**Application no: 22/02736/DISC**

**Location:** OS Parcel 9100 Adjoining And East Of Last House Adjoining And North Of, Berry Hill Road, Adderbury

## **Lead Local Flood Authority**

Objection

Drawing file: 22021-BGC-D-PL01 B Drainage Stategy Plan.pdf

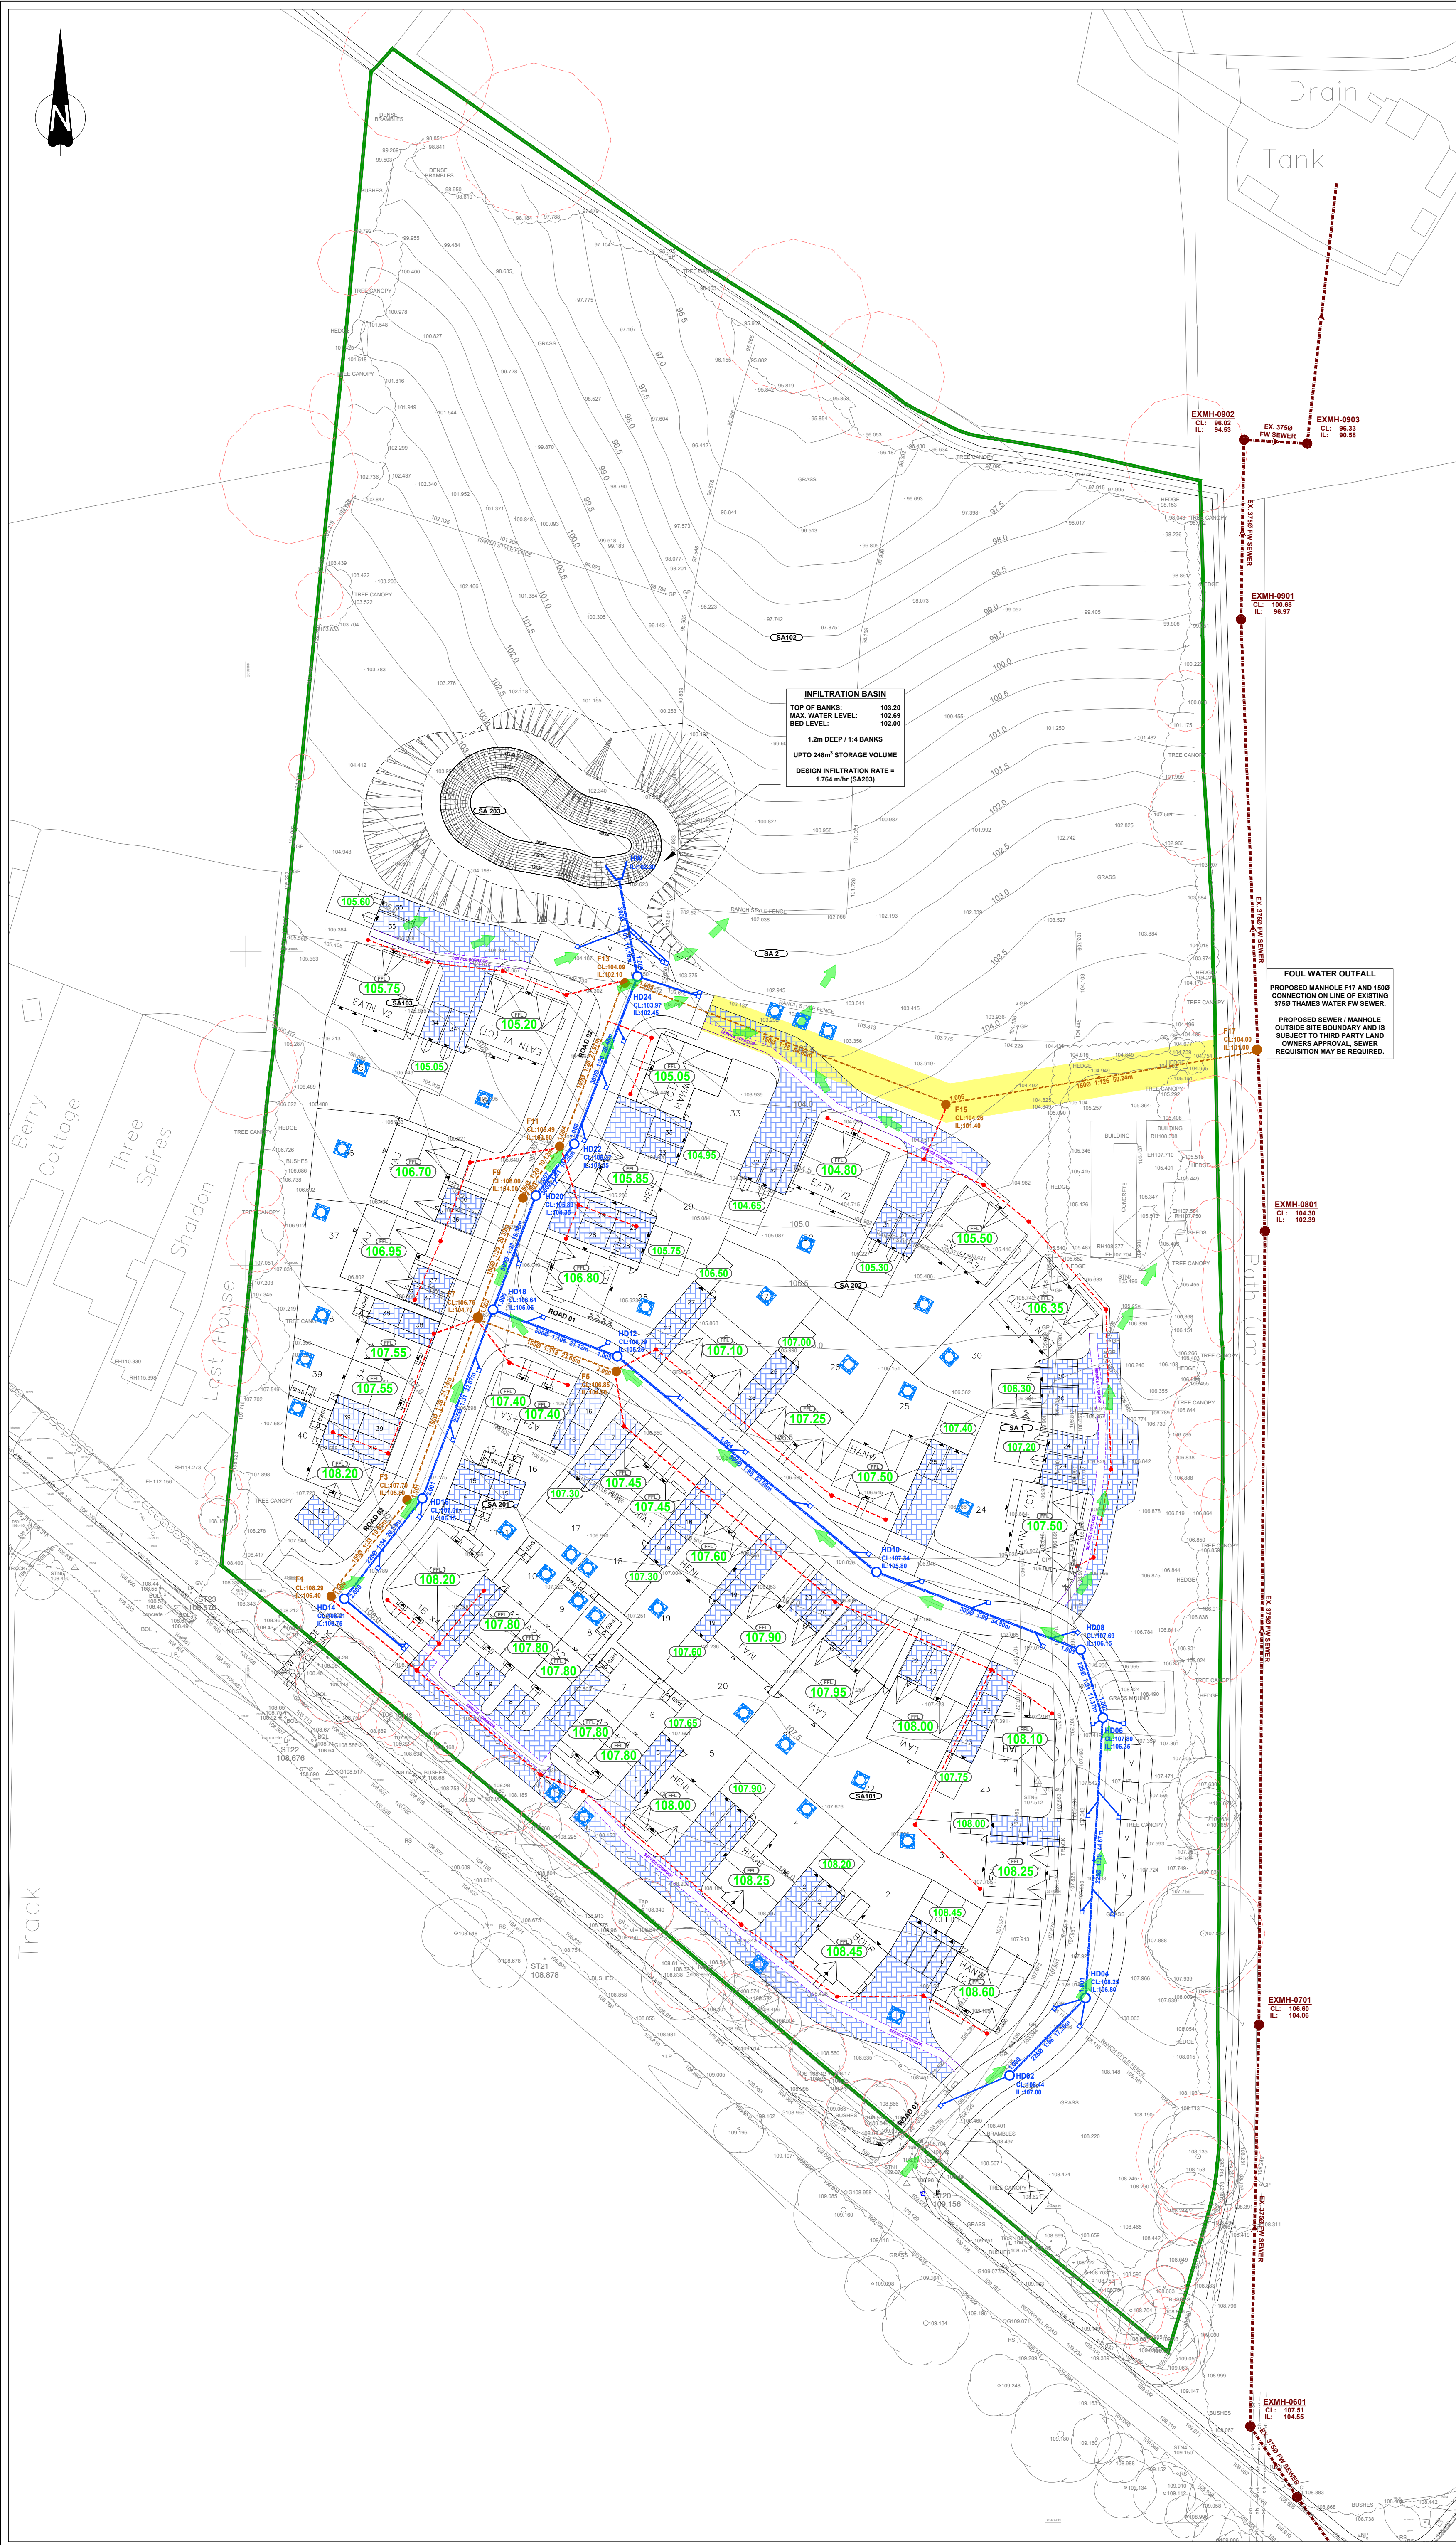
- Provide surface water catchment plan, clearly showing the extent of the impermeable areas and stating the area. It should also demonstrate to which SuDS feature it will drain to.
- Soakaways and permeable paving should be referenced on the drainage plan and read in line with the calculations. Provide calculations for all plots and permeable paving sections for all storm events up to and including the 1:100 year plus 40%.
- Plot soakaways are not showing incoming drainage pipe. At discharge of condition stage the proposed drainage should be detailed. Show the plot drainage, including cover and invert levels. Show the sizes of the soakaways.
- Provide sub base thickness on the drainage strategy drawing.
- Provide flood exceedance plan, showing that all surface water will be kept away from structures and within the site boundary.
- Provide drainage construction details drawings.
